December 10, 2013
File: 13105

RE: 133 YORK STREET
RESPONSE TO PLANNING BOARD COMMENTS

Below is our response to the Planning Board Hearing comment of November 12, 2013:

1 GROUND FLR PLAN
A-001
Scale: 1/4" = 1'-0"

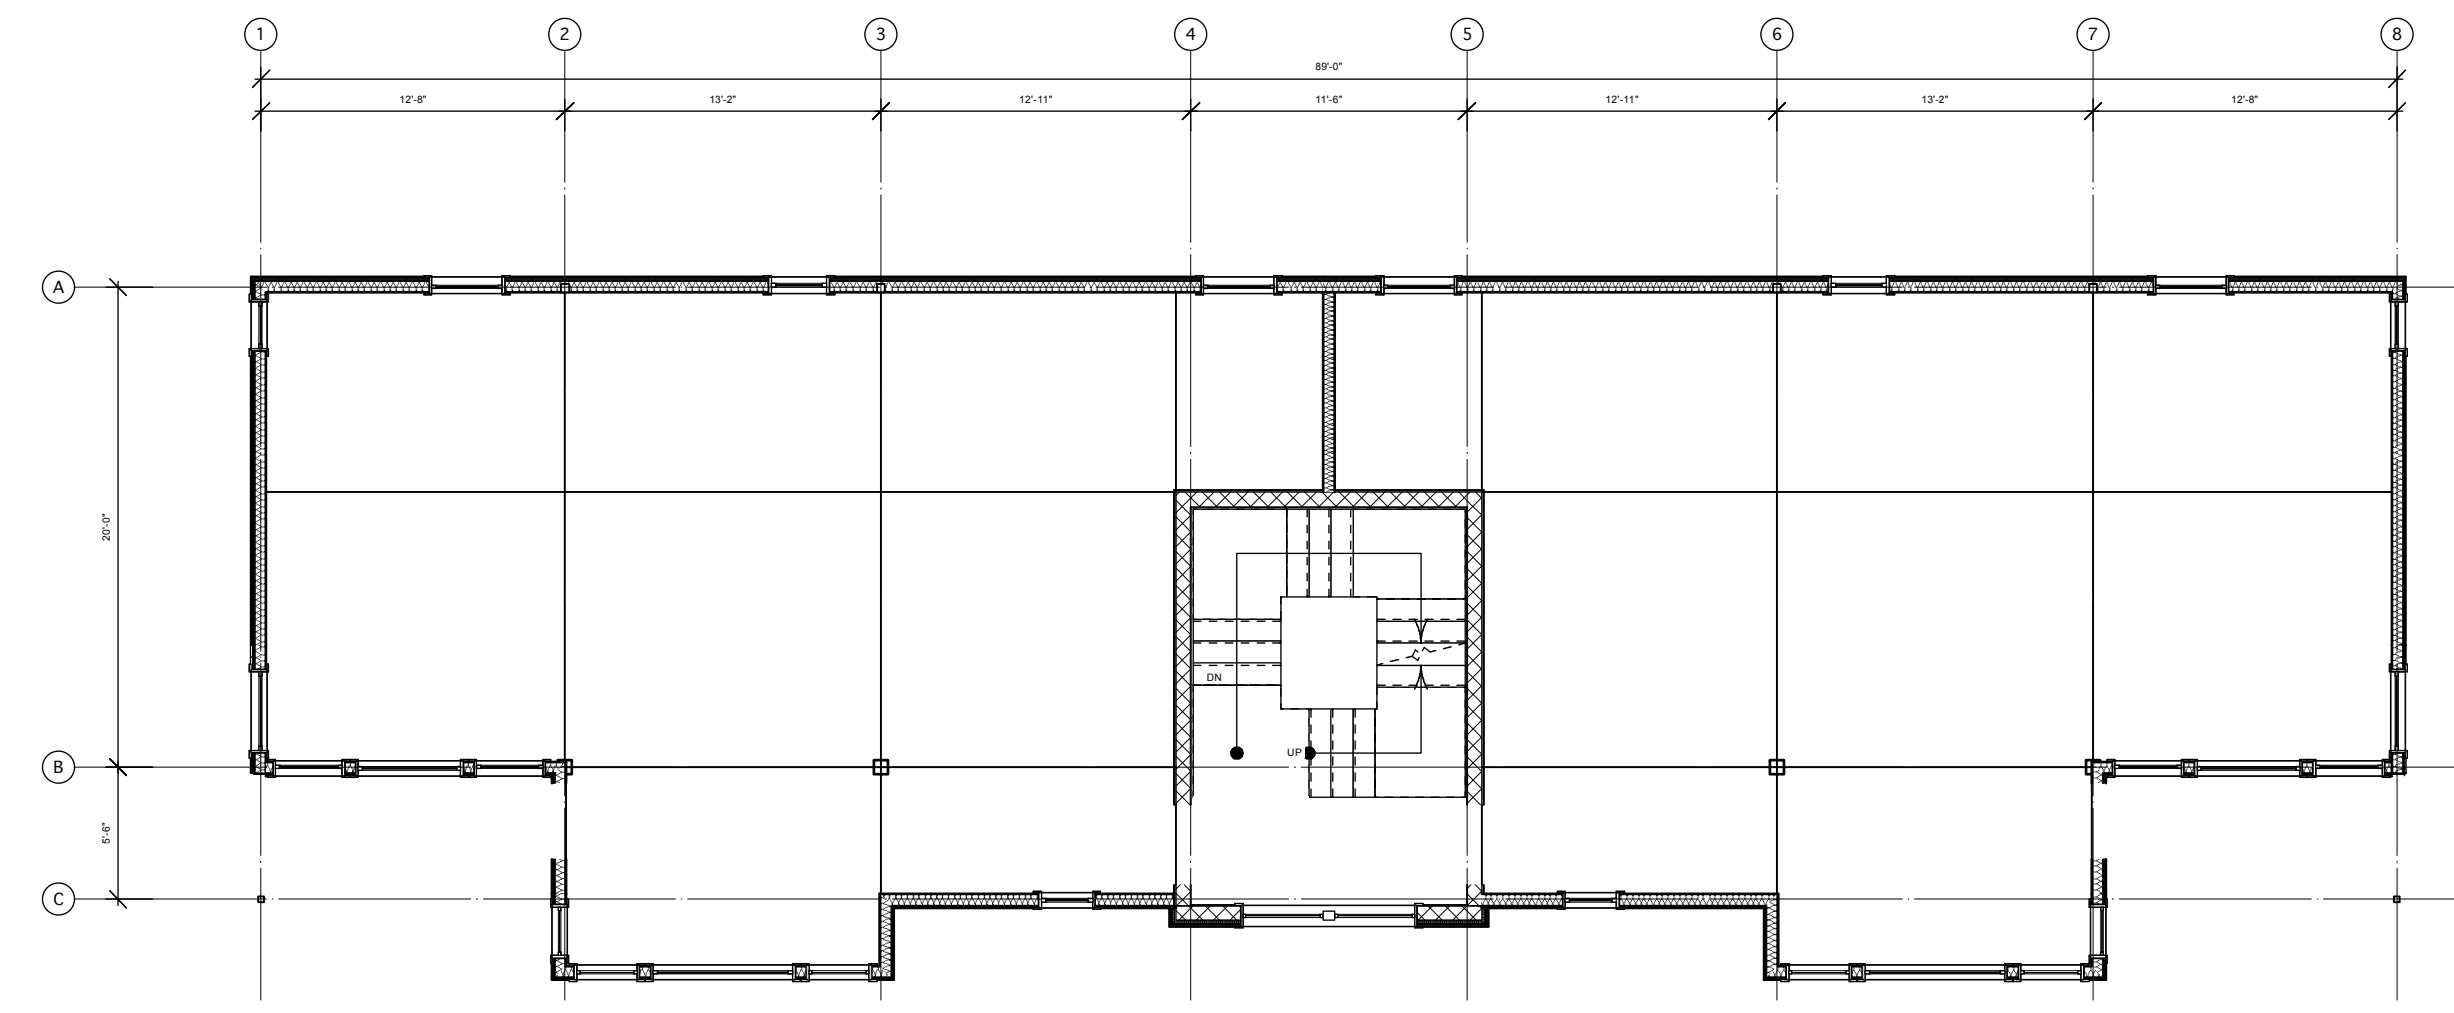
- vi. *That the applicant shall submit a revised Site Plan that relocates the bicycle parking rack so that it does not impede access to parking spaces, for review and approval prior to the issuance of a building permit; and*

Bike rack moved to interior garage wall – see architects plan A-001. These can be accessed by visitors, as there are no doors on the parking.
